Rezoning Transportation Analysis

Petition Number: 2020-087

General Location Identifier: Tax ID 03904210

Date	Description
07-22-20	First Review
08-25-20	Second Review

Drawing file: revised-site-plans / 2020_087_revsiteplan_2020_08_17.pdf

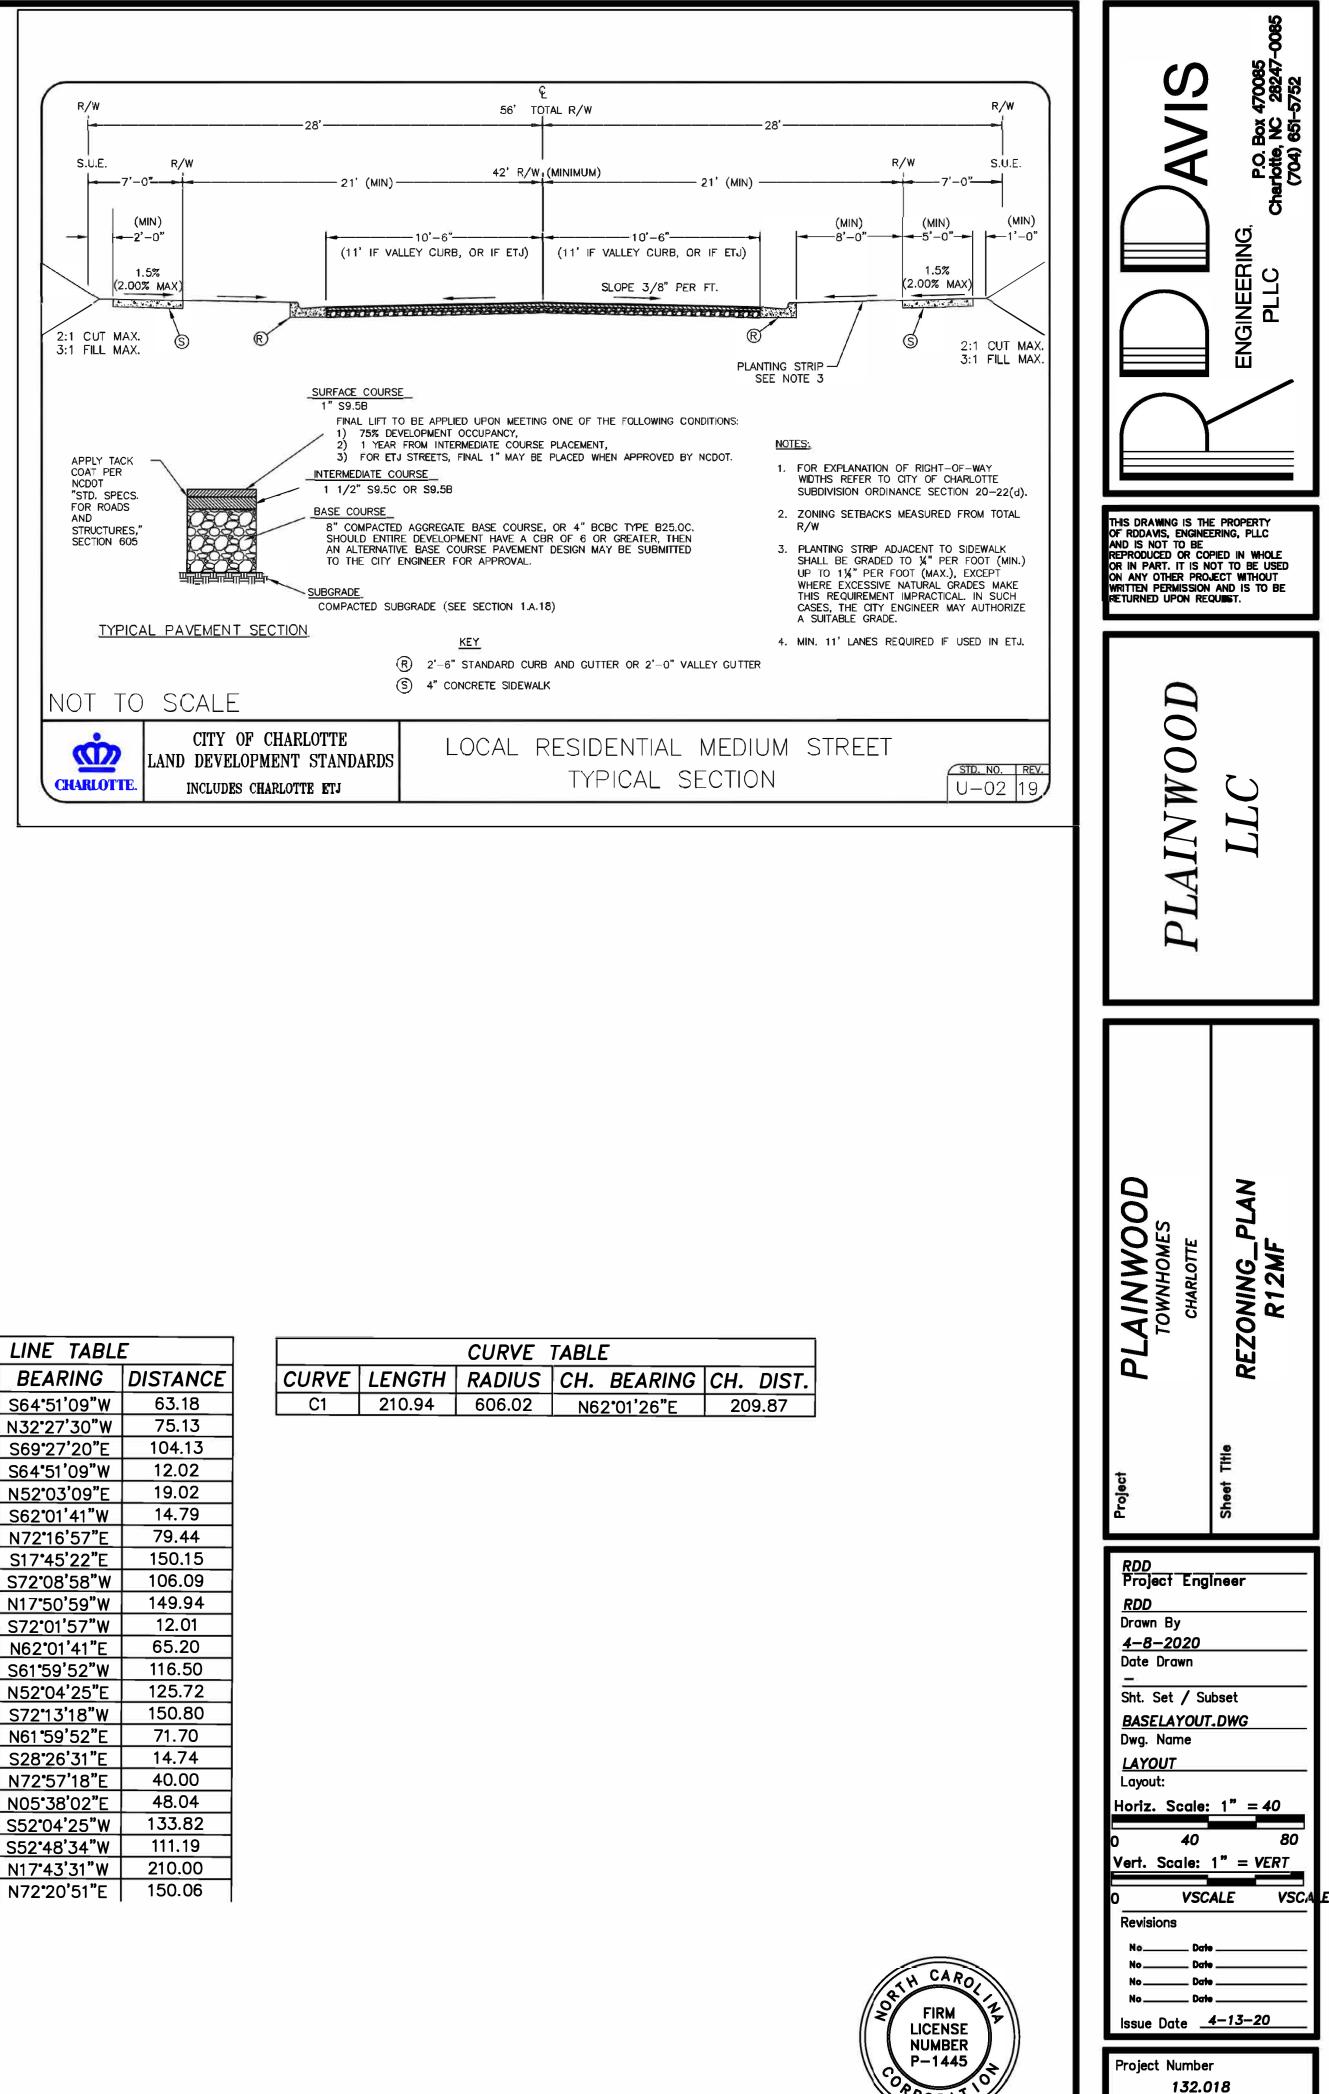
- Technical Clarification (site plan dated 8-17-20)** The petitioner should revise the site plan to condense the number of front-loaded driveways along Black Avenue, and please clarify that this street will be public.

- a. **Technical clarification (site plan dated 8-17-20)** The petitioner should revise the site plan to show and call-out the 8' planting strip and 6' sidewalk, in reference to conditional note **(Section E.1.)**

- a. **Technical clarification (site plan dated 8-17-20)** The petitioner should revise the site plan to show and call-out the 12' multi-use path along Brookshire Boulevard, in reference to conditional note **(Section E.2.)**; please remove the following language: "if not approved by NCDOT or any other applicable governmental authorities..."

- a. **Technical clarification (site plan dated 8-17-20)** The petitioner should revise the site plan to show the northbound drop right-turn lane in the proposed Brookshire Boulevard access, in reference to conditional note **(Section C.5.)**; please remove the following language: "if not approved by NCDOT or any other applicable governmental authorities..."
